DEVELOPMENT HEARING OFFICER
SUPPLEMENTAL SUBMITTAL

PROJECT NO. PR-2022-007299
Application No. SD-2024-00113

Re: Prelim / Final Plat Review for Proposed Subdivision of Tracts I-A and I-B, Coors Plaza, being comprised of Remaining Portions of Tracts I, Coors Plaza and Tracts 54 and 55, Unit 6, Town of Atrisco Grant

The comments from an initial preliminary / final plat meeting held on June 26, 2024 under PR-2022-007299 / SD-2024-00113 are addressed below:

Easement Notes

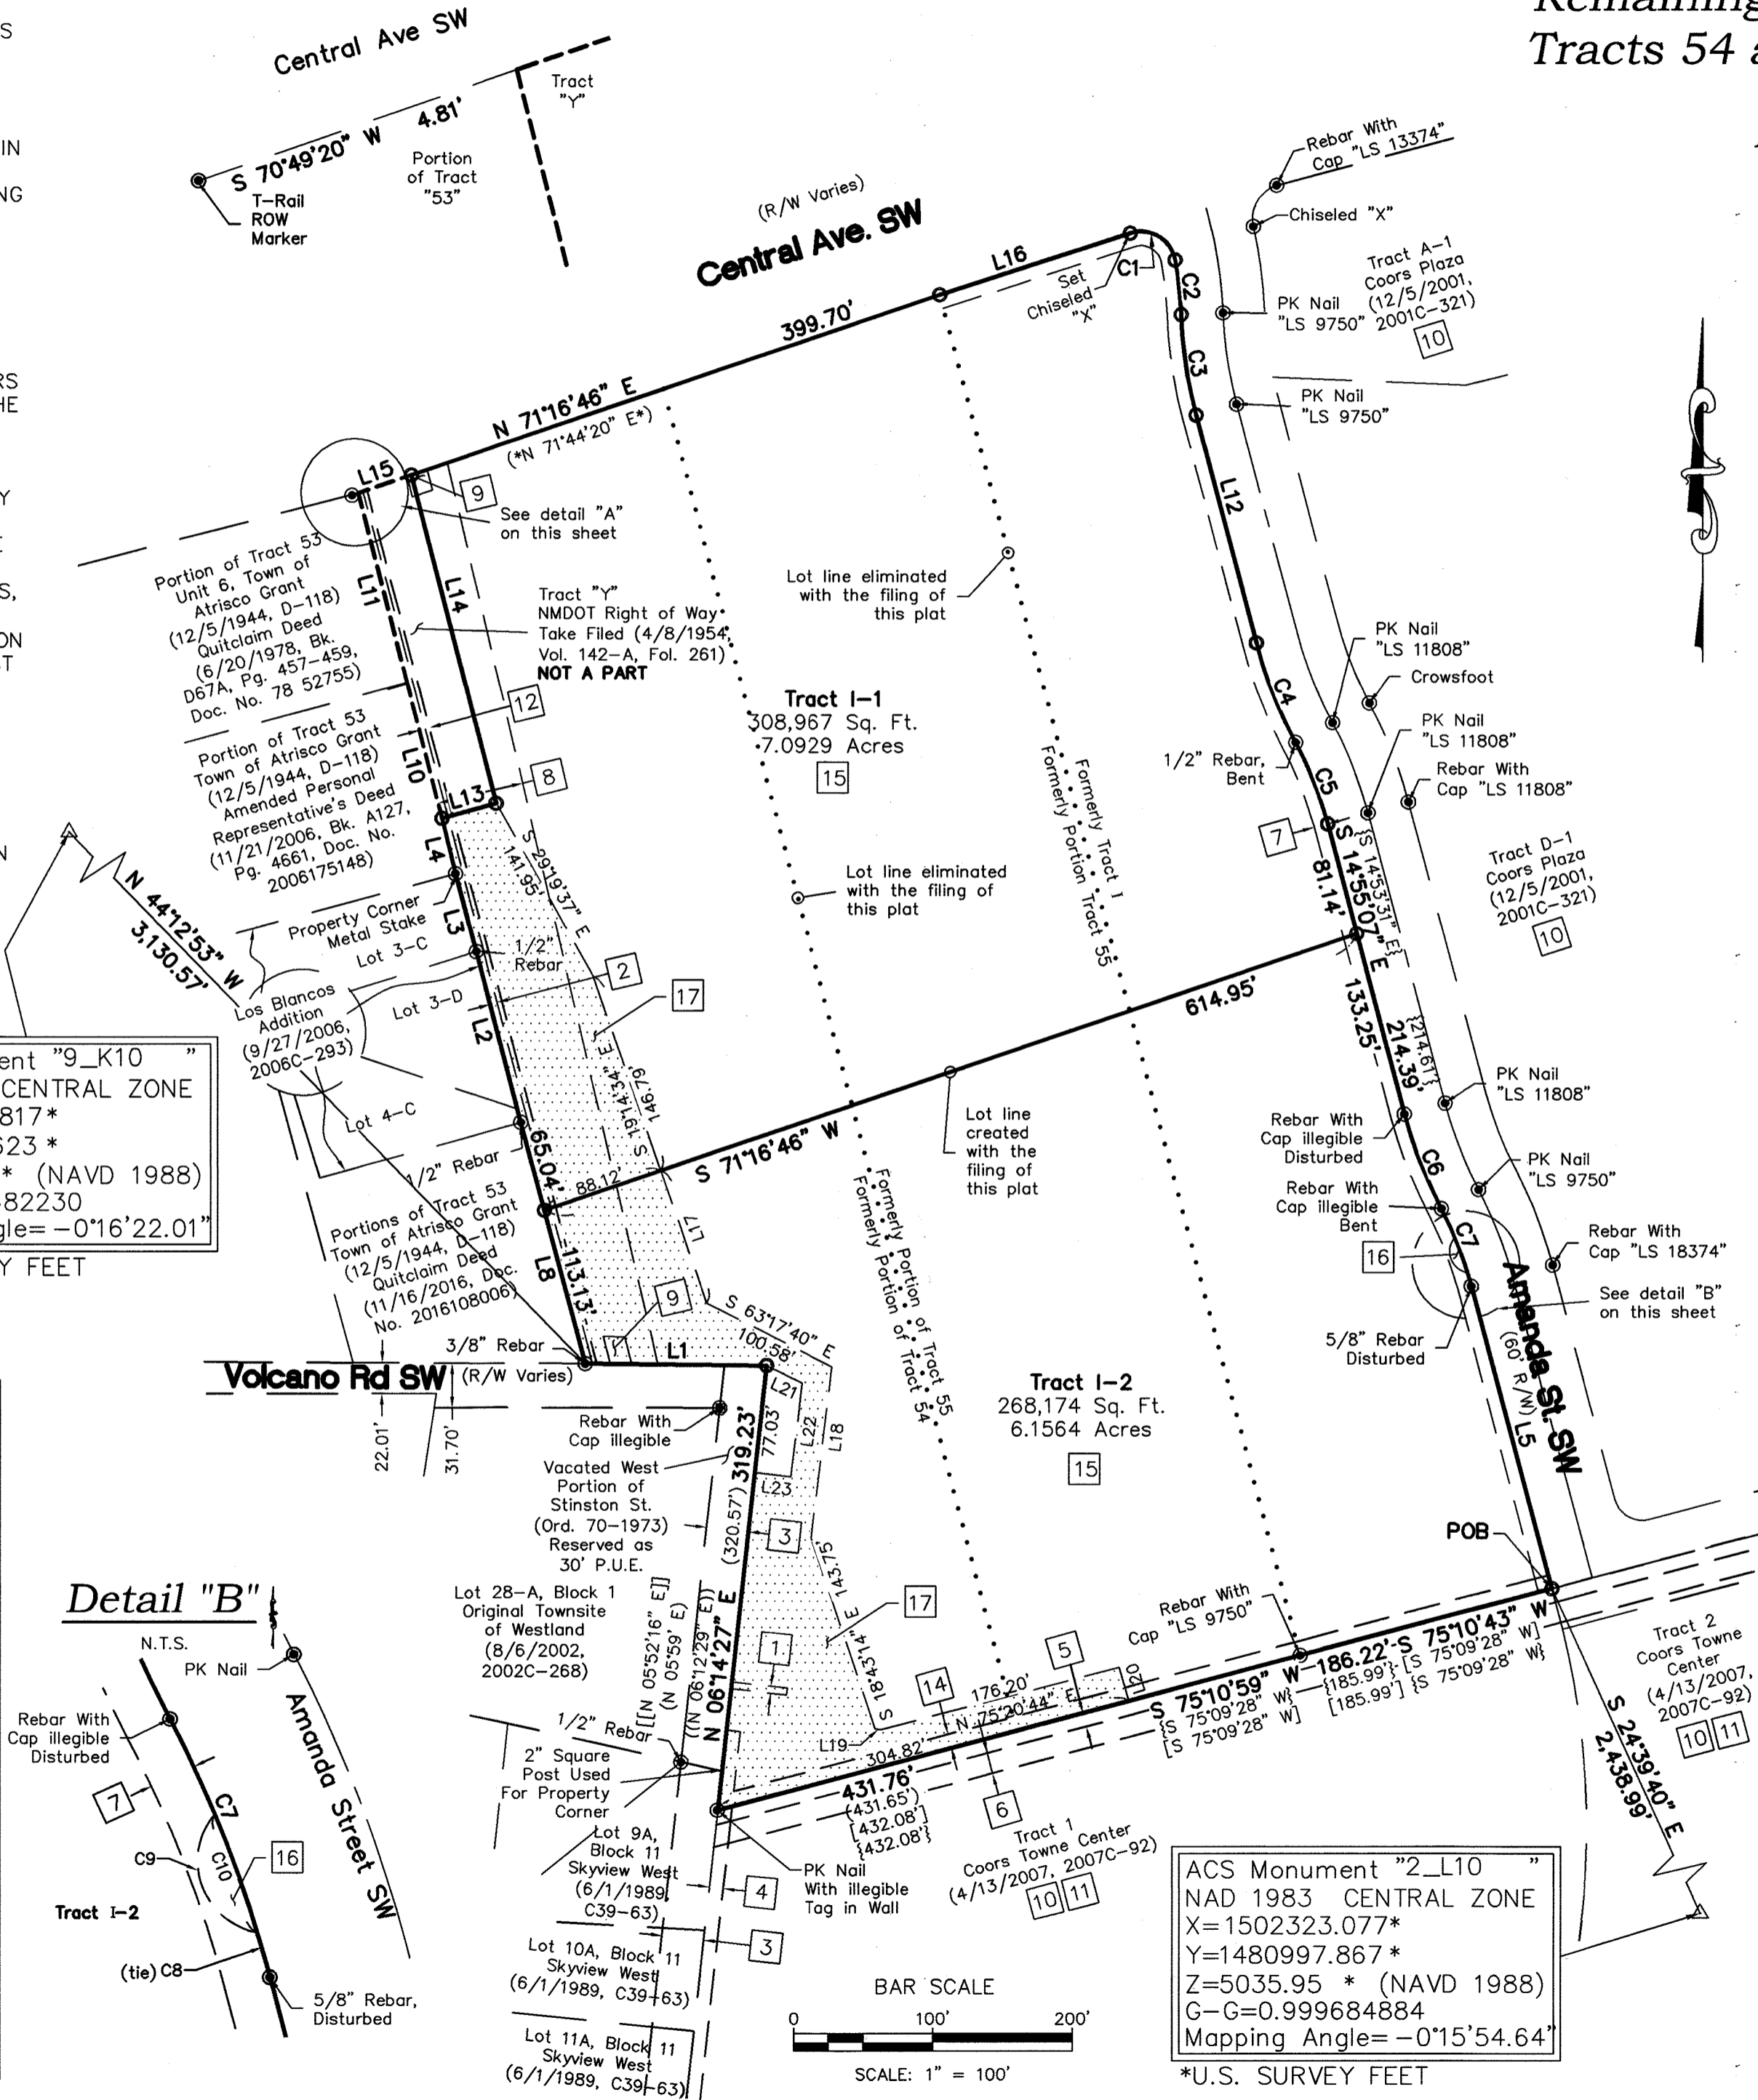
3. Please clearly identify the purpose of easement note 3 and its applicability for public water and sewer to remain within this corridor. If this is not clear, please grant a public water and public sanitary sewer easement for this infrastructure if within this property. It is not clear if this portion is part of the platted area.

- Hydrology has an approved Conceptual Grading & Drainage Plan (K10D070) with engineer's stamp 06/06/2024.
- Hydrology needs a Public Drainage Easement as shown since there is public drainage passing through this sit
- Please add the City's standard drainage easement language.

1. Central is a Principal Arterial within a center and requires 10' sidewalk with a 6' to 8' landscape buffer. Amanda St. is a local road and requires 5' sidewalk and a 4' to 6' landscape buffer. All sidewalks must have a 4-foot ADA pathway around all obstructions within right-of-way. ROW appears to be adequate along both roadways.
2. All work within the ROW shall be done under a work order and all infrastructure items placed on an infrastructure list.

Easement [3] is an off-site easement for a former portion of right-of-way, which was retained as a public utility easement and contains an existing 12” concrete sewer line

Noted, easement for public drainage is provided under note [17].

Noted, Infrastructure list attached for proposed sidewalk along Amanda Street and the asphalt trail extension along Central Ave SW are provided and should be tied to parallel site plan

application. Pathway around obstructions is addressed with new easement [16] along Amanada Street SW.
